**Planning Department
Transportation Development Services**

Re: 4th & Montano Dental Office
5508 4th St., NW
Traffic Circulation Layout
Engineer's/Architect's Stamp dated 6-2-15 (F14-D055)

4TH ST AND MONTANO DENTAL OFFICE		DRAWN BY DY
	TRAFFIC CIRCULATION LAYOUT		DATE 6/15/15
	TIERRA WEST, LLC 5571 MIDWAY PARK PLACE NE ALBUQUERQUE, NM 87109 (505) 858-3100 www.tierrawestllc.com		2014099-TCL
			SHEET # C1
RONALD R. BOHANNAN P.E. #7868		JOB # 2014099

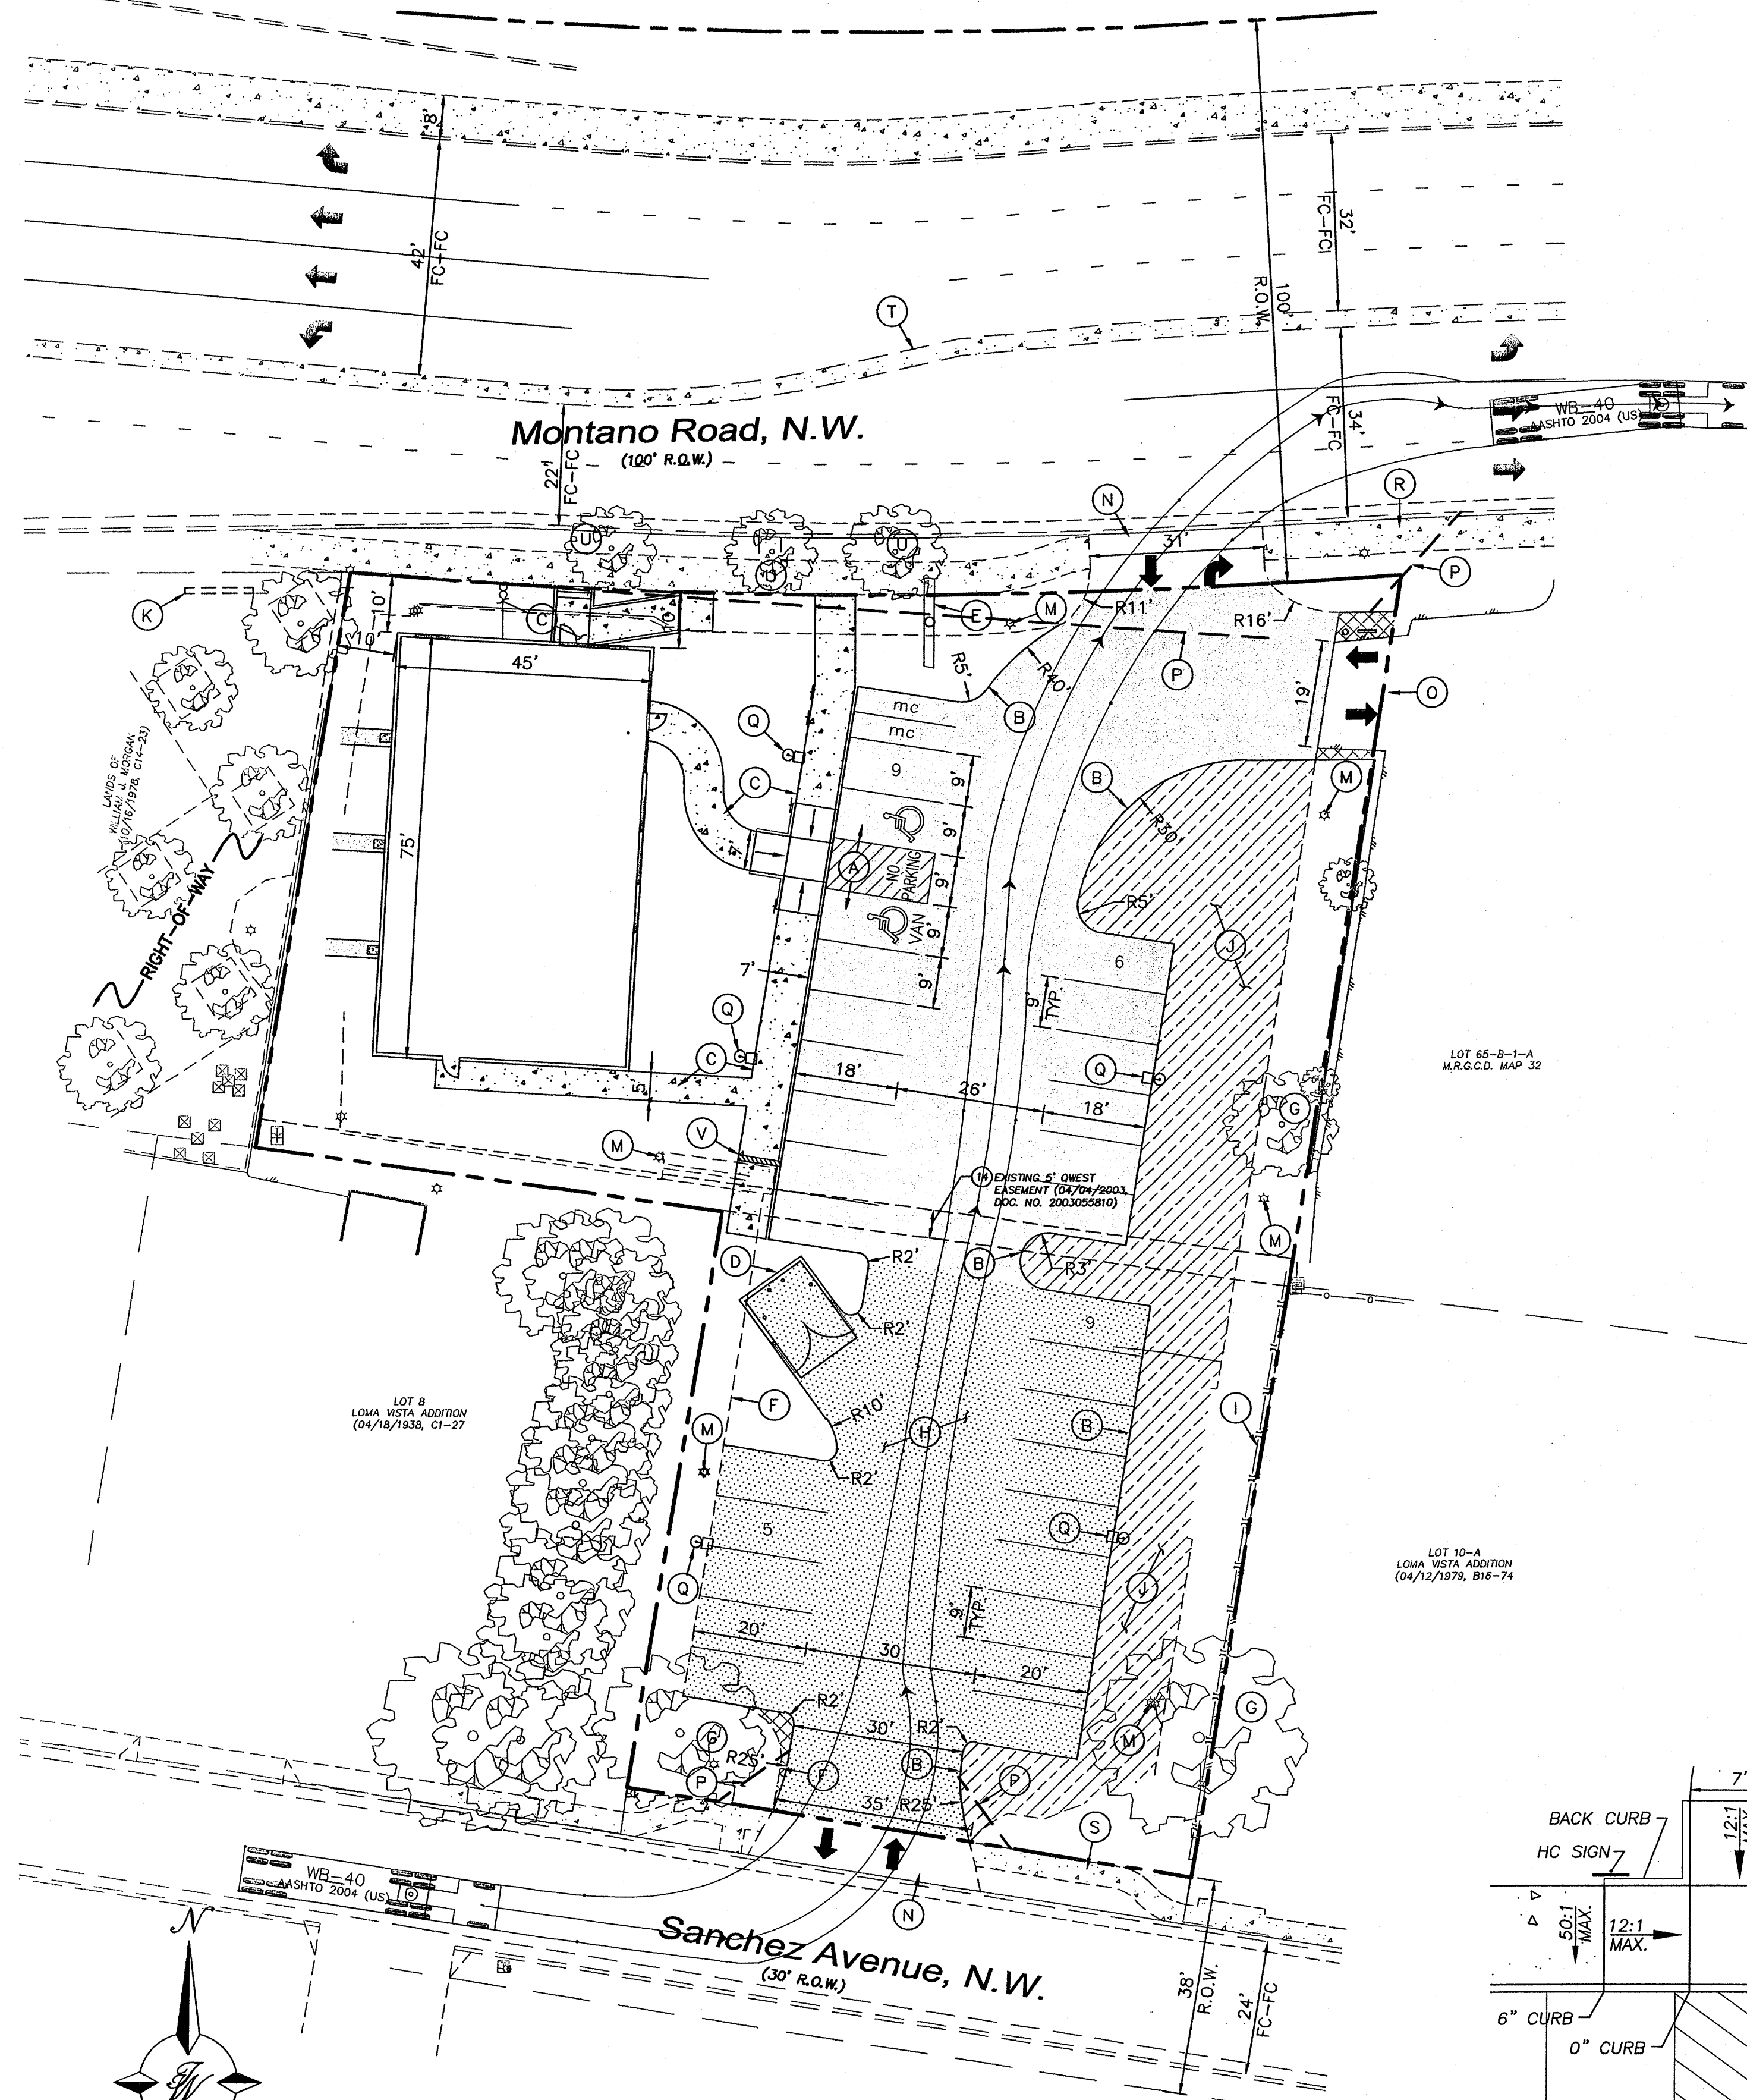
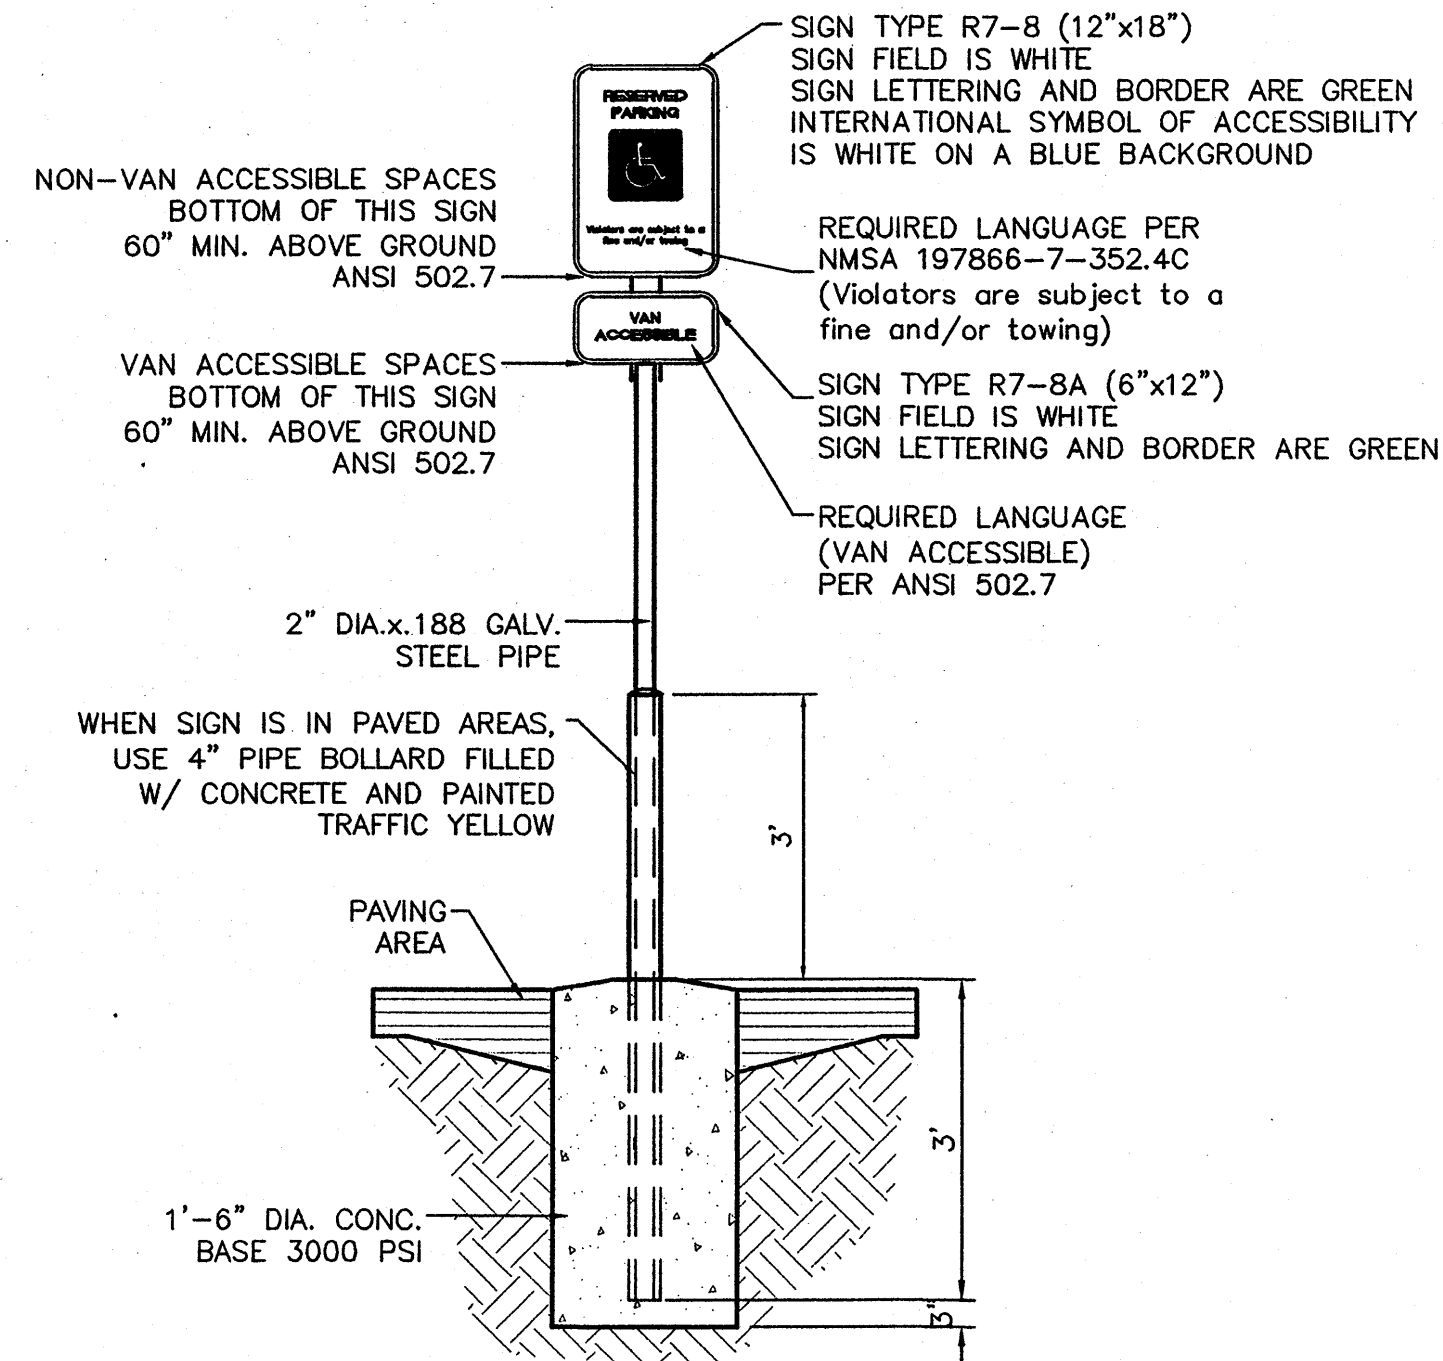
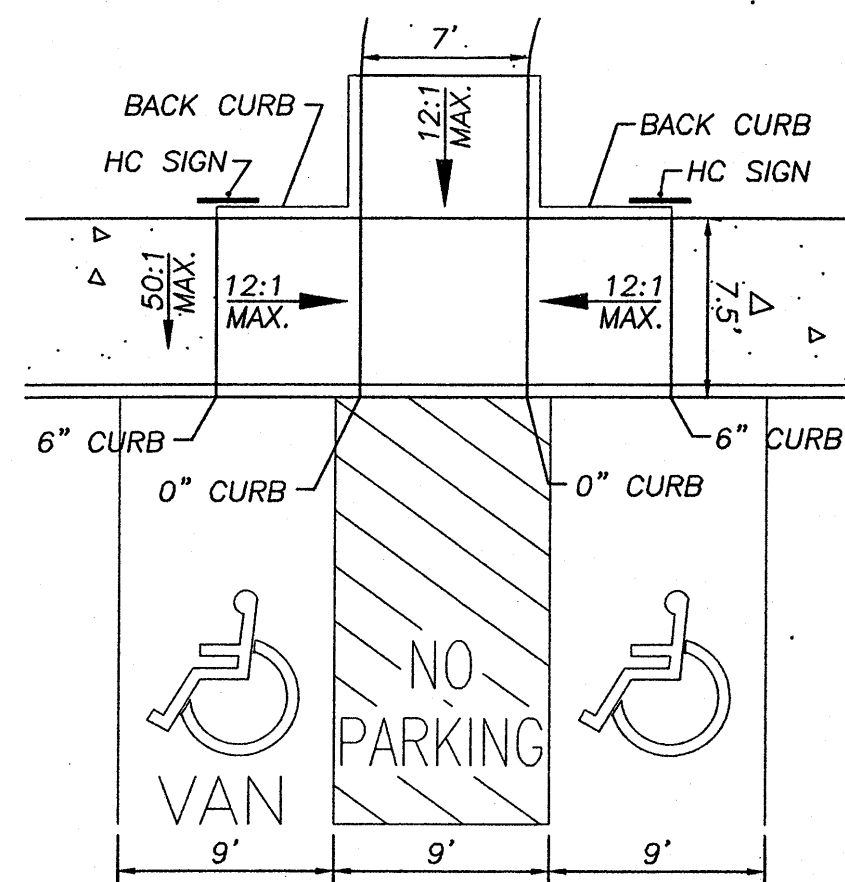
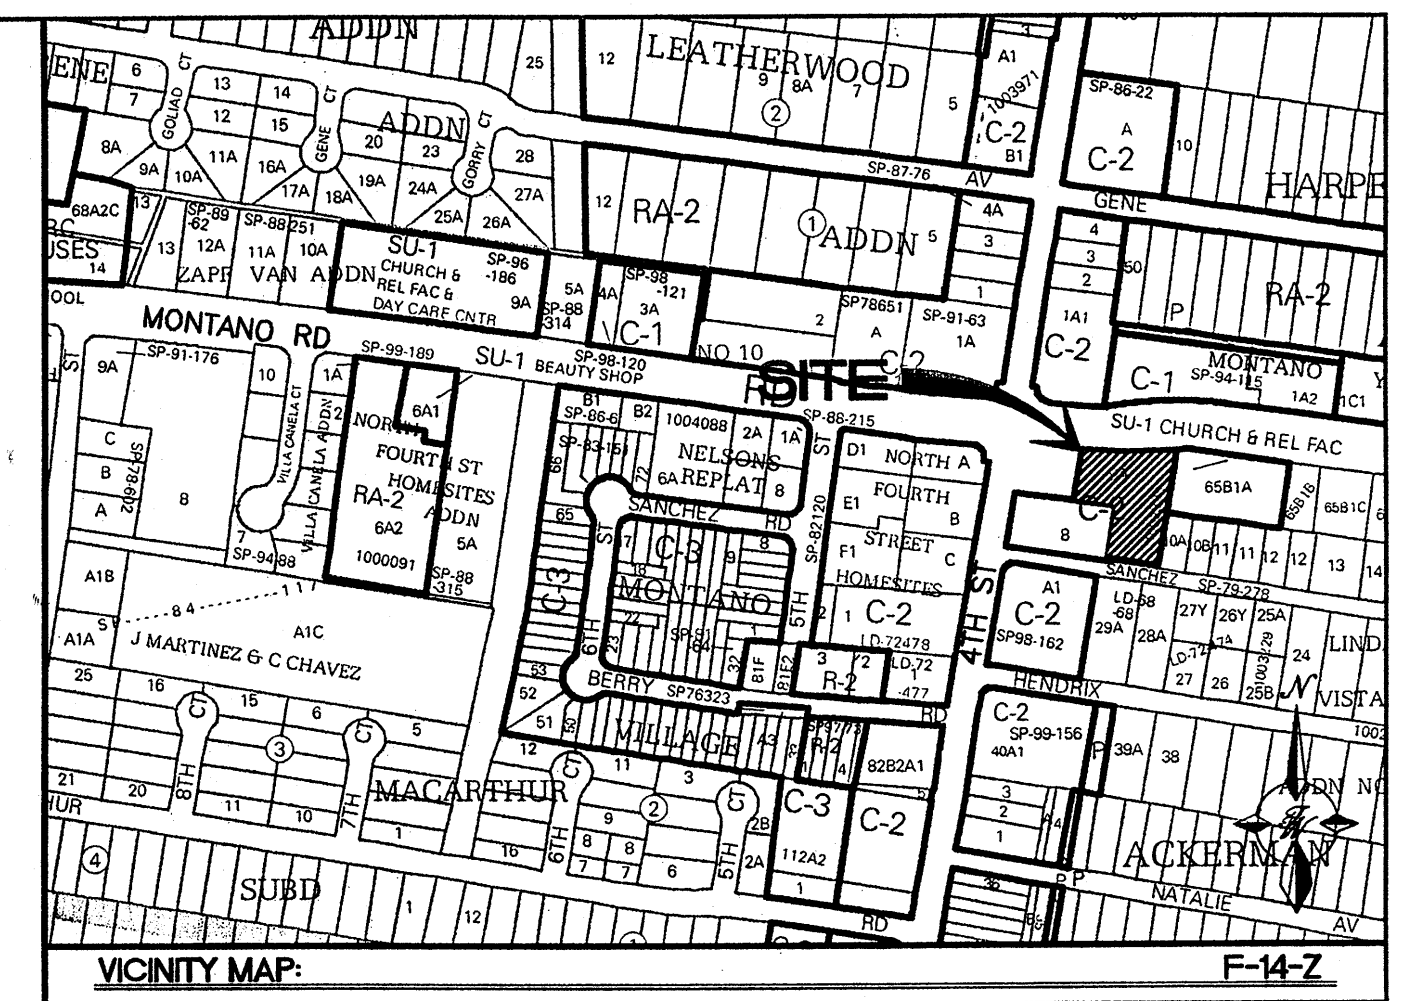
4. Please show a detail with dimensions and slope of the ADA pedestrian walkway transition from the ADA parking spaces.
5. The ADA van accessible sign must have the required language per 66-7-352.4C NMSA 1978 **"Violators Are Subject to a Fine and/or Towing."** Please show a detail of this signage.
